Consultation Response from KC, Conservation & Design**2024/91501 16, Nabbs Lane, Slaithwaite, Huddersfield, HD7 5AU****Erection of front porch (within a Conservation Area)****Date Responded: 16.7.2024****Responding Officer: Sue Brooks****Responding Ref:**

4 PROPOSED FRONT ELEVATION  
1:50@A1

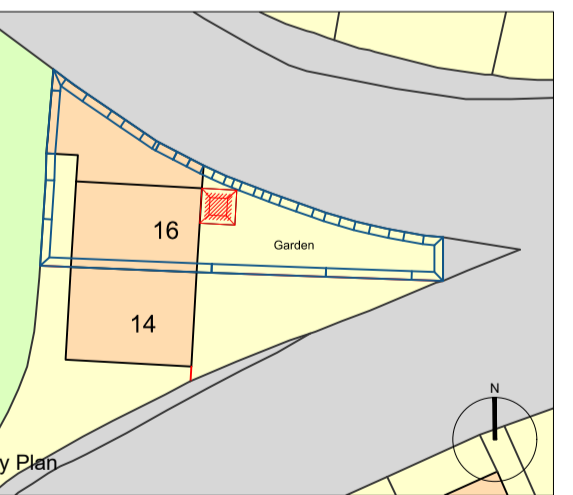
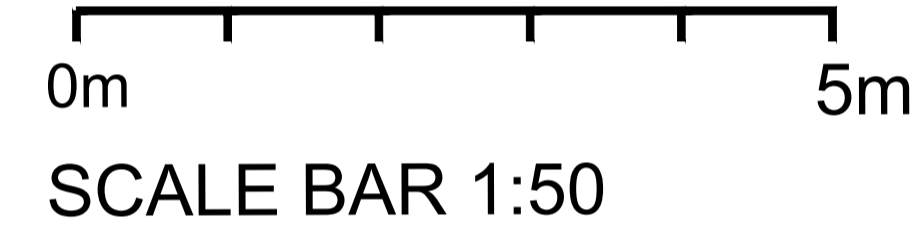
This retrospective application is for a glazed oak framed front porch with a dual-pitched blue slate roof, with a coursed stone north elevation and dwarf wall. This substantial porch structure obscures the doorway up to the height of the moulding and disrupts the symmetry of the elevation by introducing a large dual-pitched structure on this otherwise low-key elevation. It is highly visible when viewed from the east from both Nabbs Lane and Howgate Road, due to its position to the right of the façade, the elevated position and the low boundary wall of the front garden. The materials – a heavy oak frame and expanse of glazing, are out of character with the local vernacular which is typified by natural stone.
